PROJECT NAME: UNSW G25 Education Building

SSD-74670005

**[Objections to Proposed Development - SSD-74670005 at 8 High Street, Kensington, NSW, 2033 - Lot / DP Lot 5 DP 1264171]**

Figure 71 Extract of proposed plans showing Elevation – South

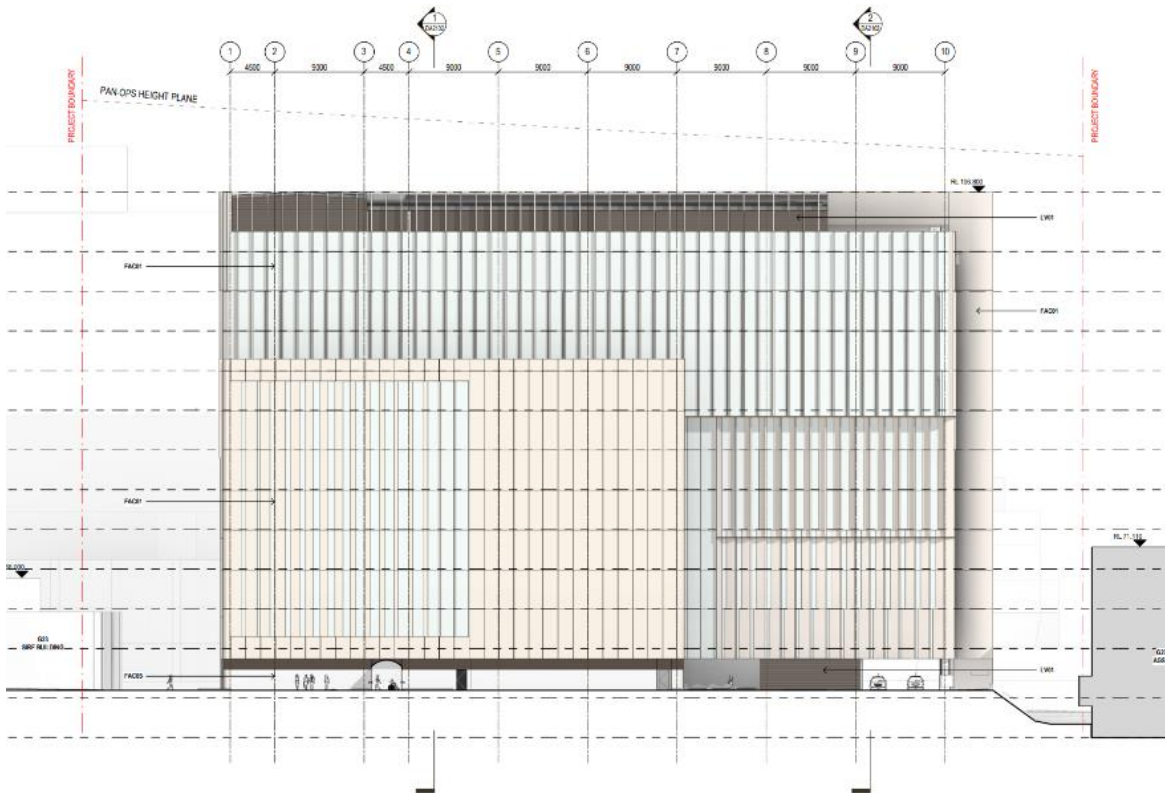
### **South Facing Windows**

It is our understanding based upon viewing the current plans, that there will be large windows lining the south side of the building right up to the top level. Based on our calculations from Level 7-8 and above, these South facing windows would offer unobstructed views into the surrounding properties on:

Given the close proximity to our residential property (14a Norton), our day to day activities will be visible to students and staff that attend the UNSW campus on these levels.

We would request that consideration is given to the choice windows and fittings on the south side of the building on levels that are constructed above the 7th floor. There are such fittings that would allow for light to enter the floors from the south side, but also limit the viewing capability of those on the floor to see out.

We would like to engage in a conversation with the planners regarding the design of floors that have the ability to overlook residential properties. Alternatively a change to the proposed height of the build would negate some of the issues above. Limiting the build to 8 floors for instance.
